WEST SUSSEX COUNTY COUNCIL CONSULTATION

TO:	Arun District Council FAO: Mr. S. Davis
FROM:	WSSC - Highway Authority
DATE:	9 March 2022
LOCATION:	Land to the south of Ford Lane and east of North End Road Yapton BN18 0DS
SUBJECT:	Y/10/22/PL Erection of 15 No dwellings (including 4 No affordable units) with associated access, parking, landscaping, drainage and public open space (additional units to those approved under application Y/123/21/PL). This application may affect the setting of a listed building, affects the character & appearance of the Church Lane Conservation area, affects a Public Right of Way and is in CIL Zone 2 and is CIL Liable as new dwellings.
DATE OF SITE VISIT:	n/a (visited previously for other applications on the site)
RECOMMENDATION:	More Information Required
S106 CONTRIBUTION TOTAL:	TBA

[illegible]

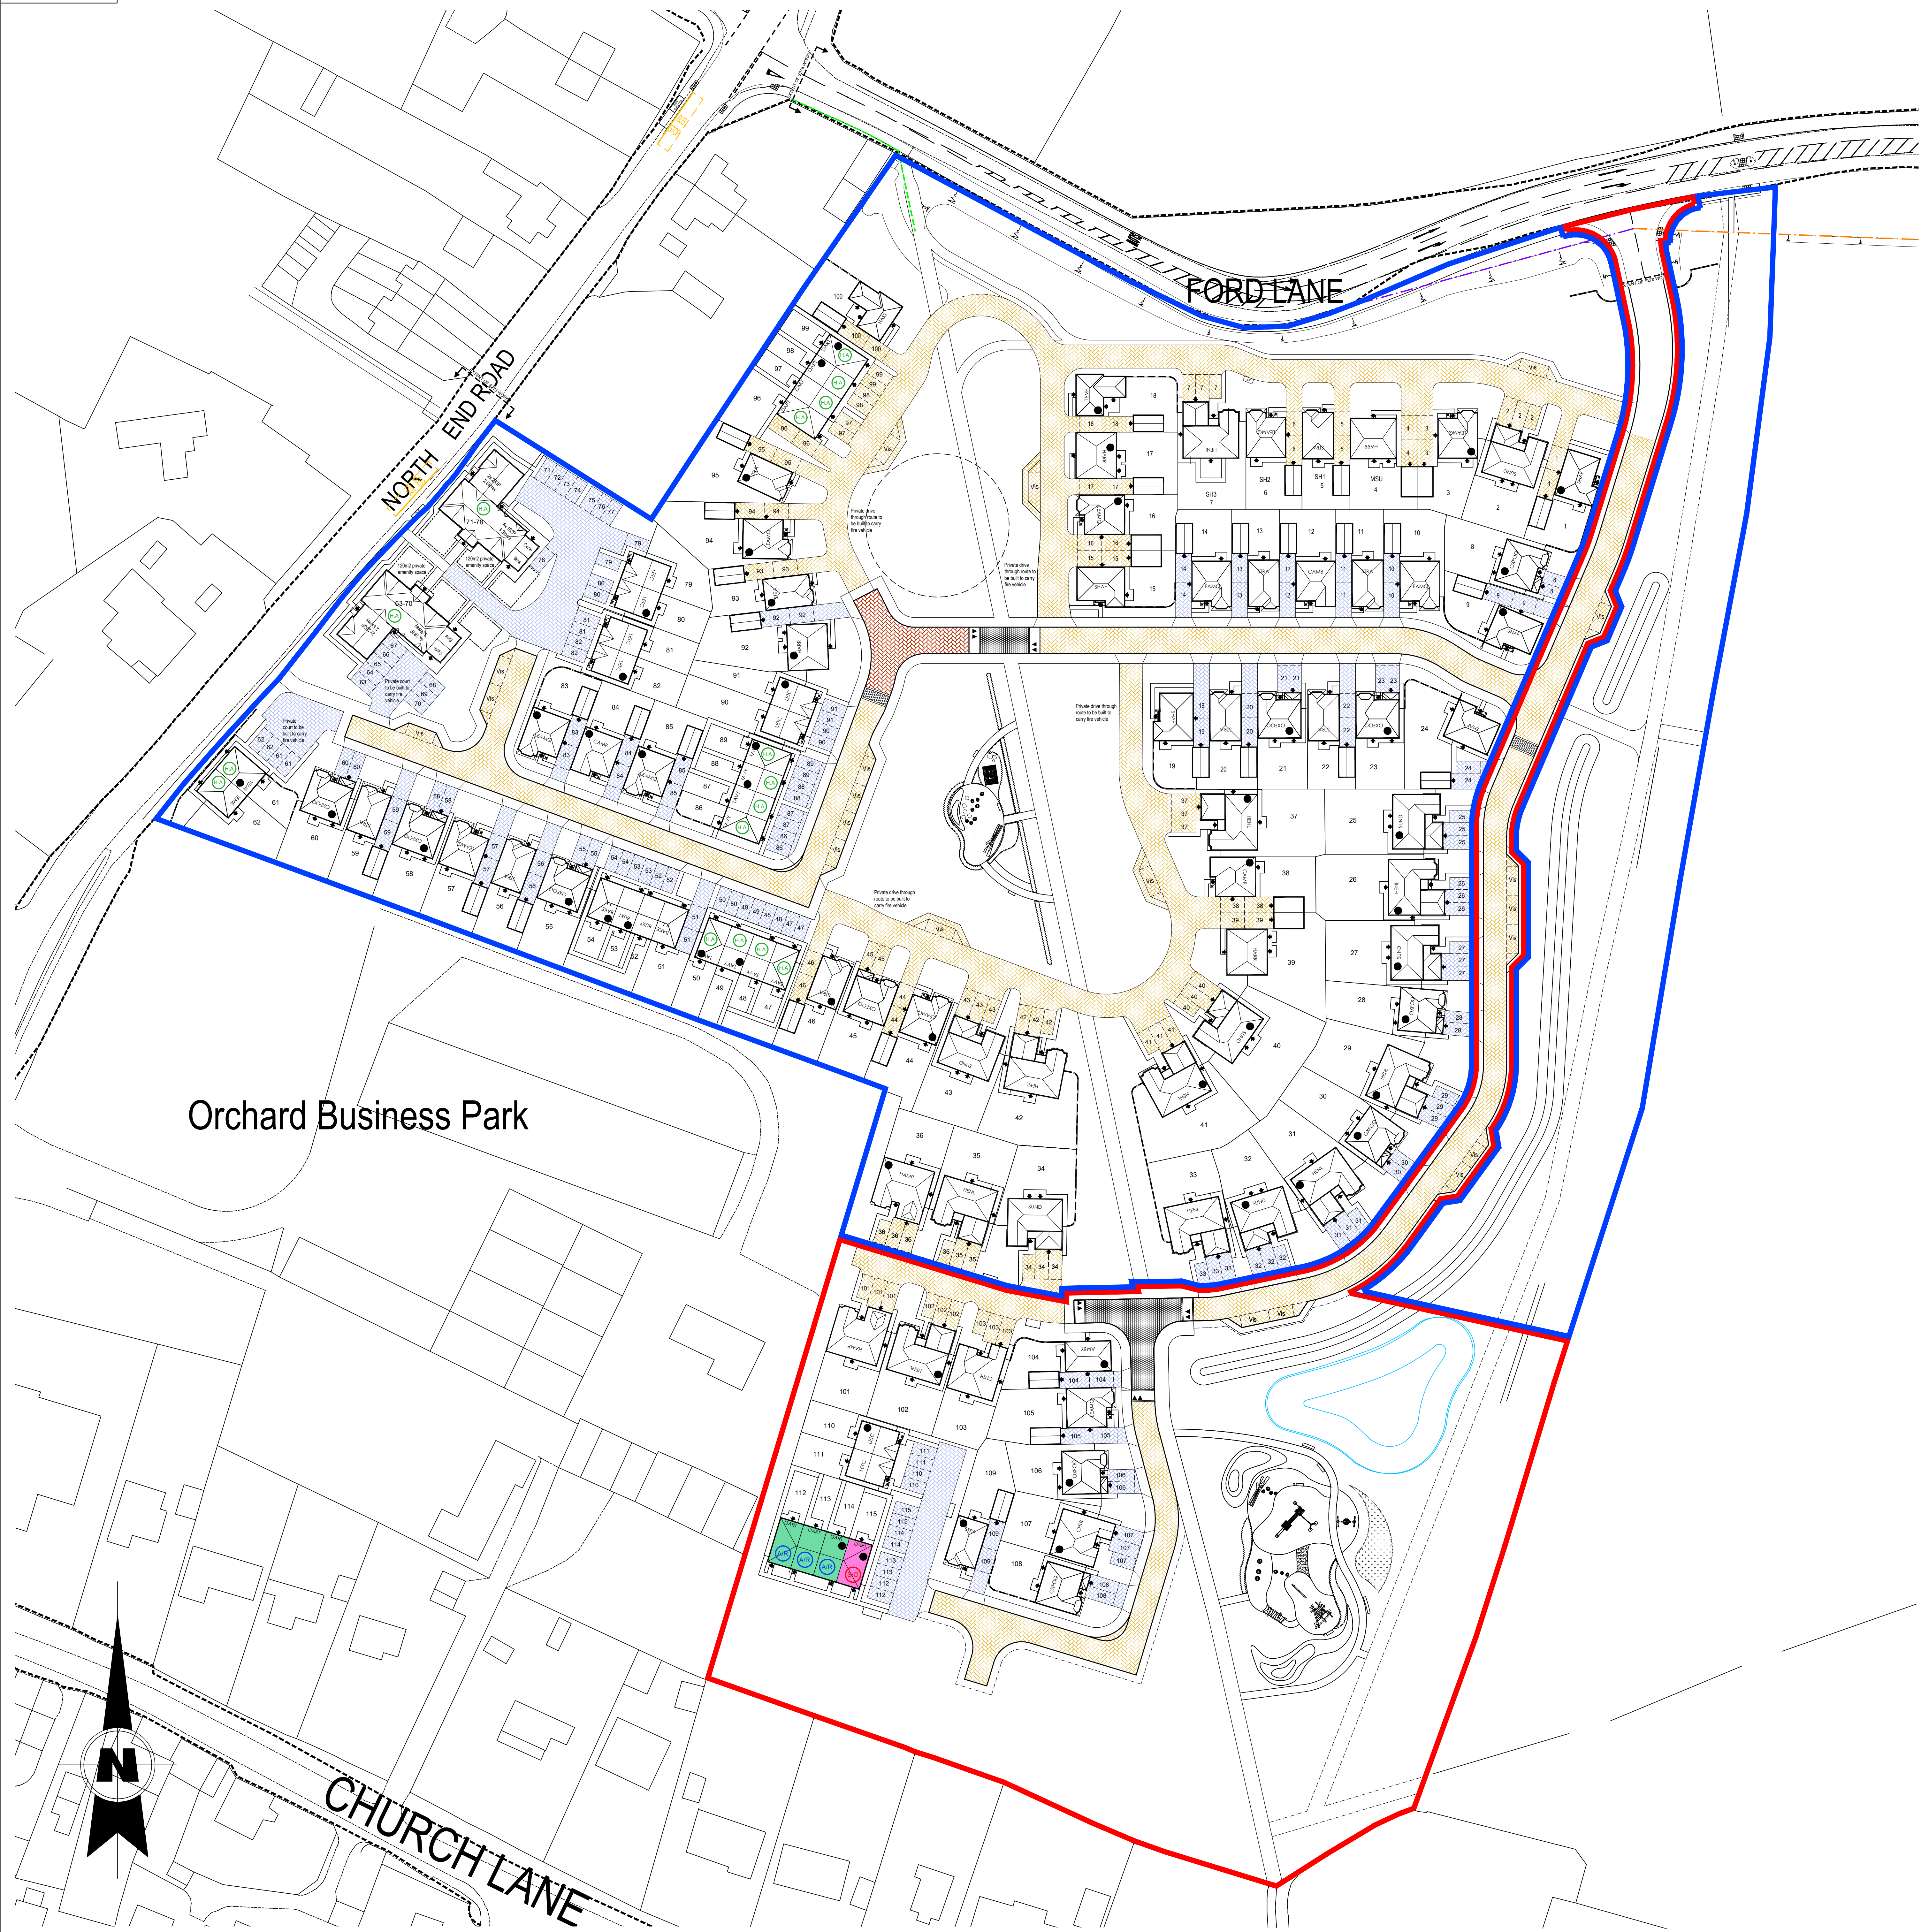
However, turning to this latest application, the turning head is now shown eastwards and again across the legal line of Public Footpath No. 357, thereby raising the previous CHA concern about future upgrading. As such, the CHA requests that the applicant re-visits this and provides an alternative that would allow for future upgrading of the Footpath to Bridleway and/or cycle path.

Parking - No visitor parking is shown provided for the new homes. Applicant to provide this.

Manoeuvring for cars - Width of manoeuvring area behind spaces serving plots 101-103 looks to be less than 6.0m. Applicant to show that a minimum dimension of 6.0m will be provided to assist vehicles entering and leaving parking spaces.
